COUNTY COUNCIL'S RESPONSE TO CONSULTATION ON THE FOLLOWING DEVELOPMENT PROPOSAL

Application No: 20/00123/OUT

Proposal: Outline application for a food store including access and scale

Location: Cotefield Business Park, Oxford Road, Bodicote,

Figure R - Illustrative External Elevations

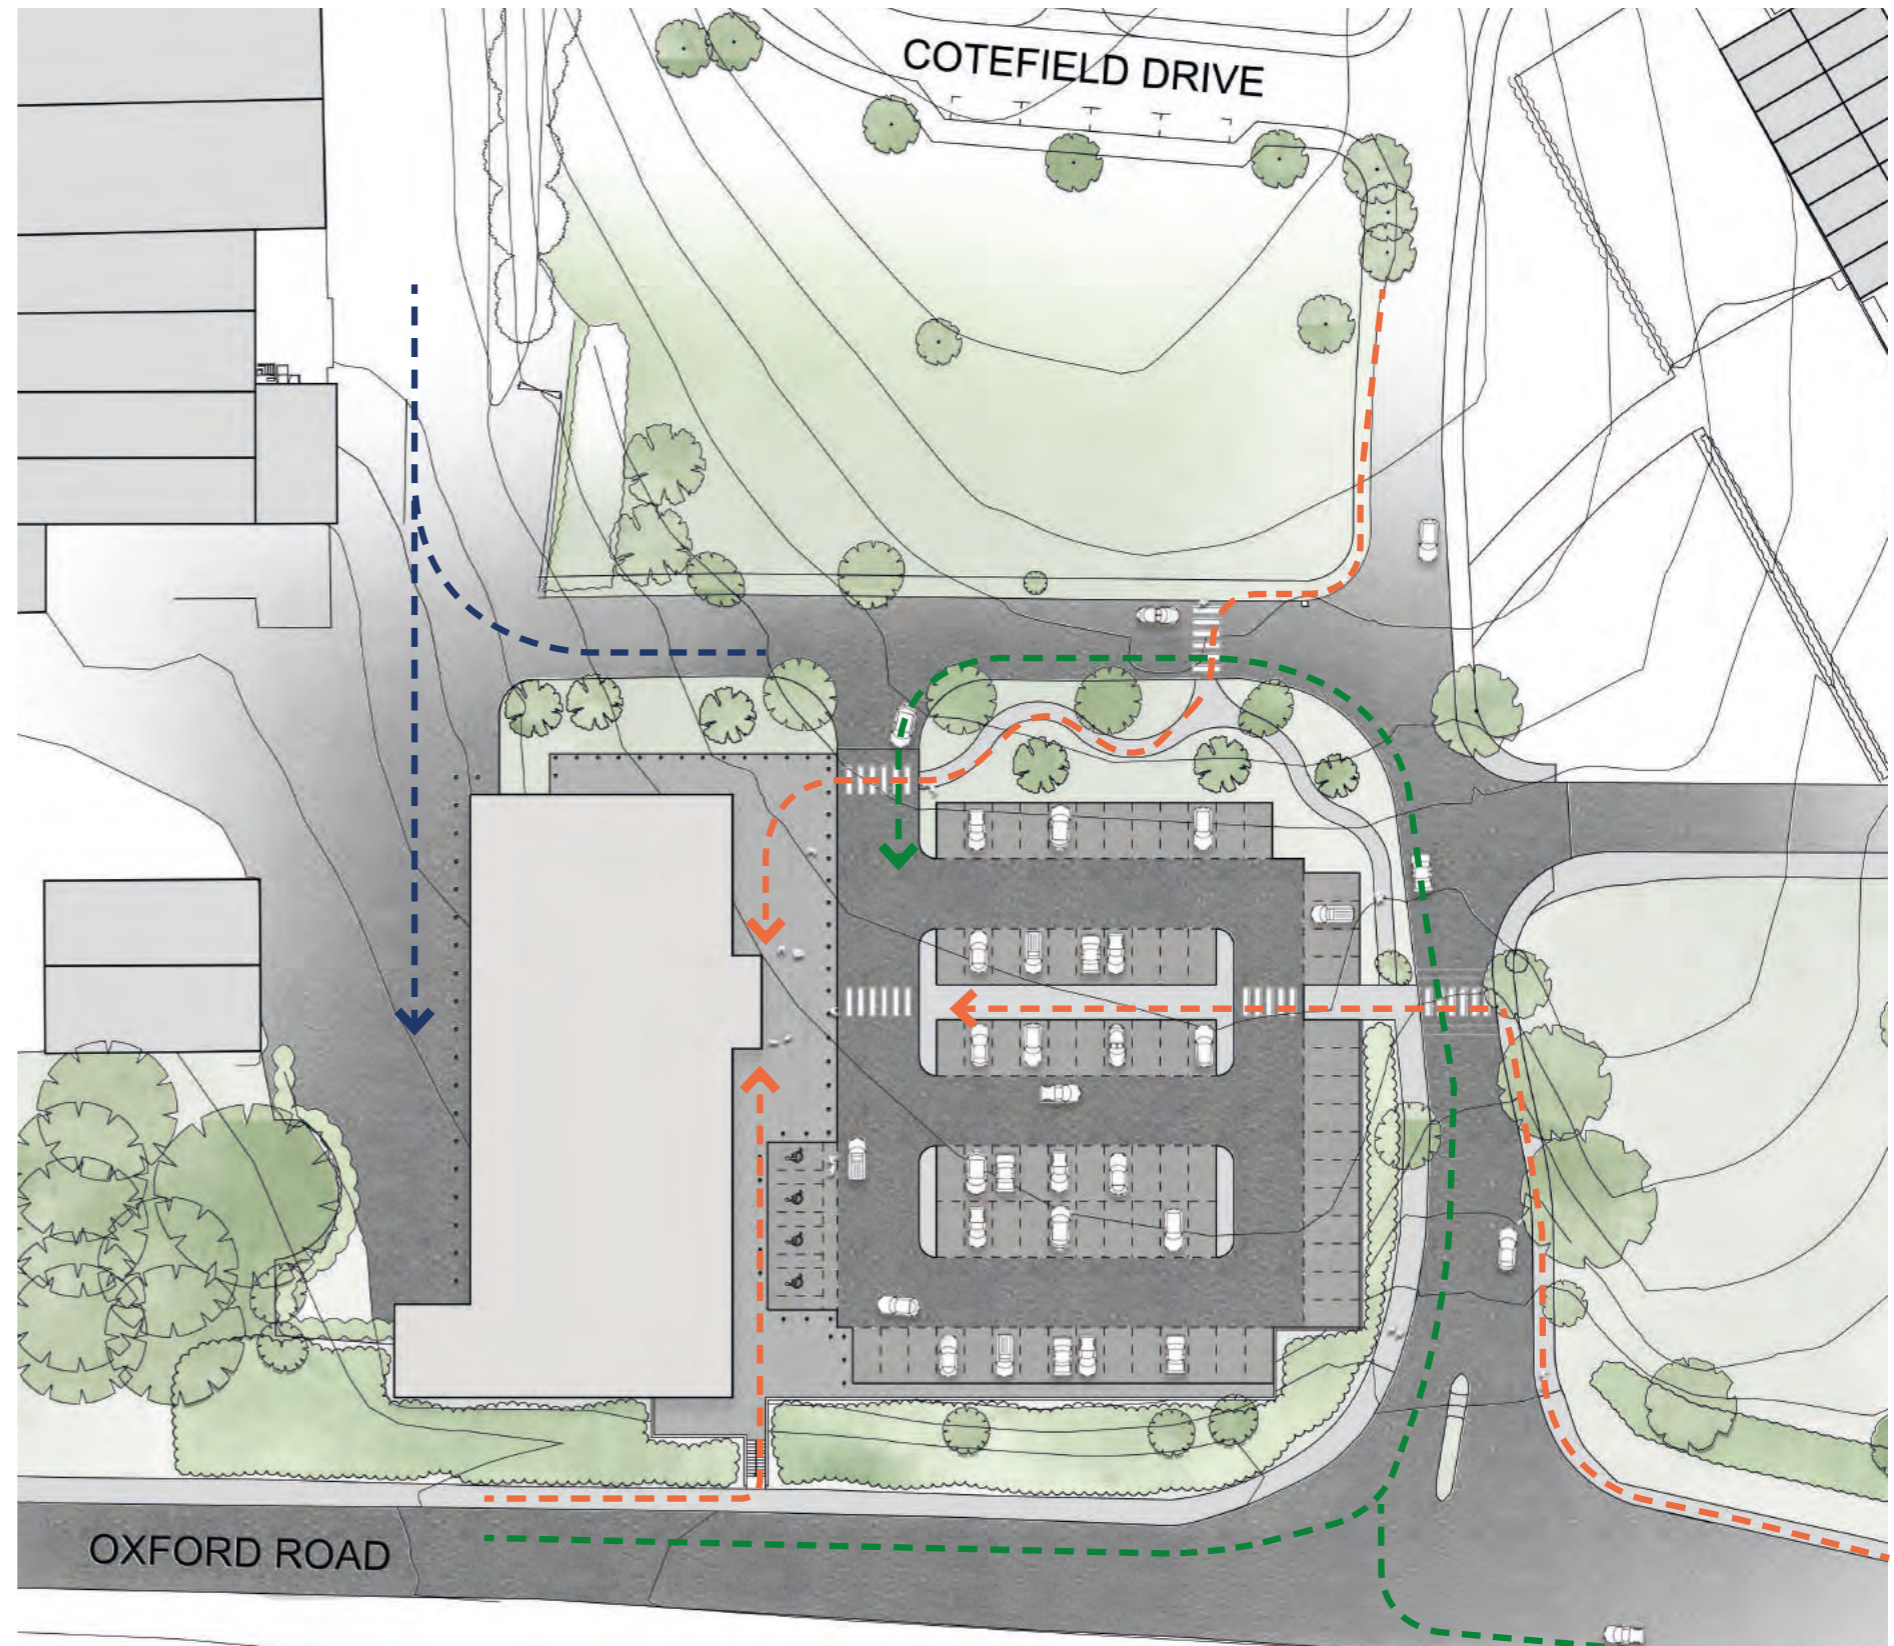
The development site is conveniently located for residents of the new Cotefield housings estates and the business park. Pedestrian routes to the front of the store are available from three directions. The Proposed Site Plan appears to indicate zebra crossings in two places on the access roads but these are not likely to be appropriate or necessary considering the footfall and limited volume of traffic. Informal crossings points with dropped kerbs and tactile paving will probably suffice.

The Transport Assessment (TA) states that cycle parking will be provided in accordance with standards. However, cycle facilities are not indicated on the Proposed Site Plan and the proposed parking is not quantified in the TA.

The layout of the car park appears to be logical, although no allowance has been made for one or more trolley bays, if they should be required. Aisle widths between parking bays need to be a minimum of 6.0m to allow safe manoeuvring into and out of spaces.

OCC guidelines are one stand per 12 staff (or 600sqm) plus one stand per 200sqm for visitors, where one stand equals two spaces. This would result in around seven stands for this proposal, although I would hope that considerably more could be provided in this instance as there is great potential for cycling in this area. Details of cycle parking are requested by condition.

Prior to the first use or occupation of the development hereby permitted, covered cycle parking facilities shall be provided on the site in accordance with details which shall be firstly submitted to and approved in writing by the Local Planning Authority. Thereafter, the covered cycle parking facilities shall be permanently retained and maintained for the parking of cycles in connection with the development.
